Your Ref: OWPC25308
Our Ref: R/268/19/PL 14-11-2019
Please ask for:
Mrs A Gardner

Demolition of existing garage & store on existing dwelling & erection of 1 no. four-bed chalet style dwelling (re-submission of planning ref: R/72/19/PL).

6 Manor Road Rustington

PROPOSED ELEVATIONS - GARAGE

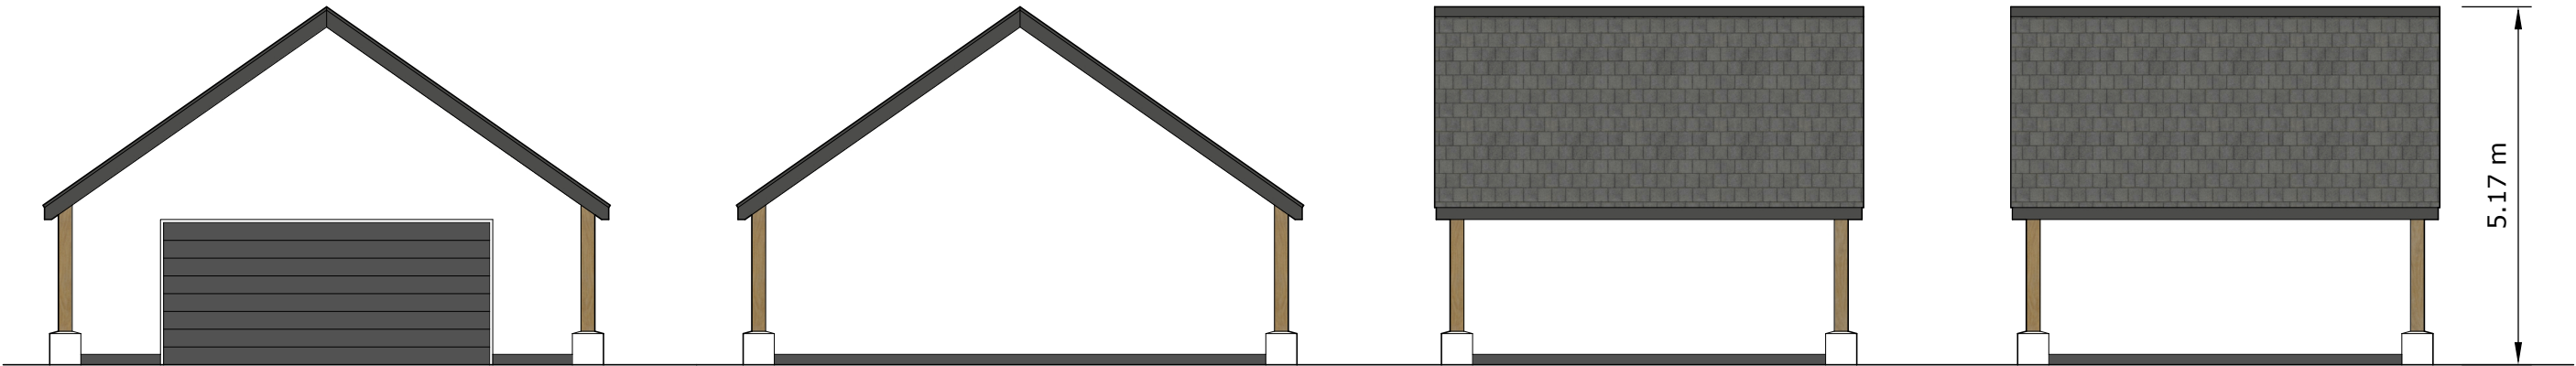
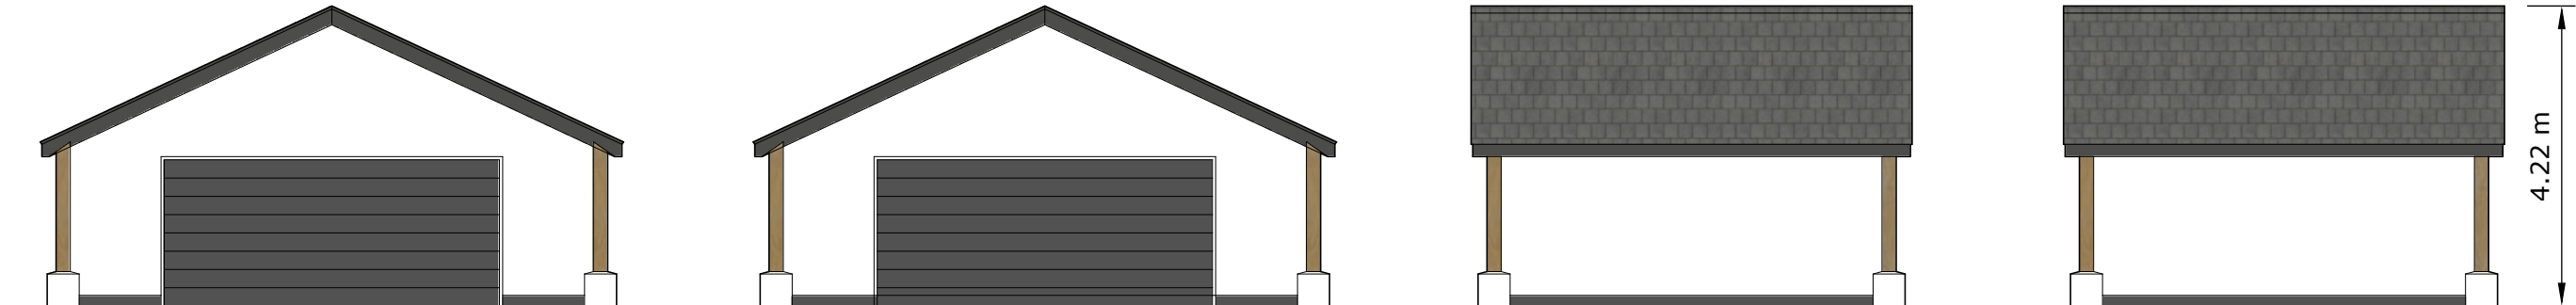
In response to planning application R/268/19/PL, I wish to make the following comment. With regards to the submitted plans, these are an improvement on those previously submitted and more in line with the surrounding existing properties. However, I wish to comment on the proposed garage which will run parallel with our garden. Although I see a need to build one as this will be accommodating a four bedroom property and therefore the proposed number of vehicles, I question whether the construction of a pitch roof and height of the garage really needs to be as high as the drawing is showing (5.17m) as well as being only 1 metre away from our boundary. I ask that the agent reconsiders this height and design so the pitch height can be significantly reduced so as to not have such a negative visual impact on our view from our garden.
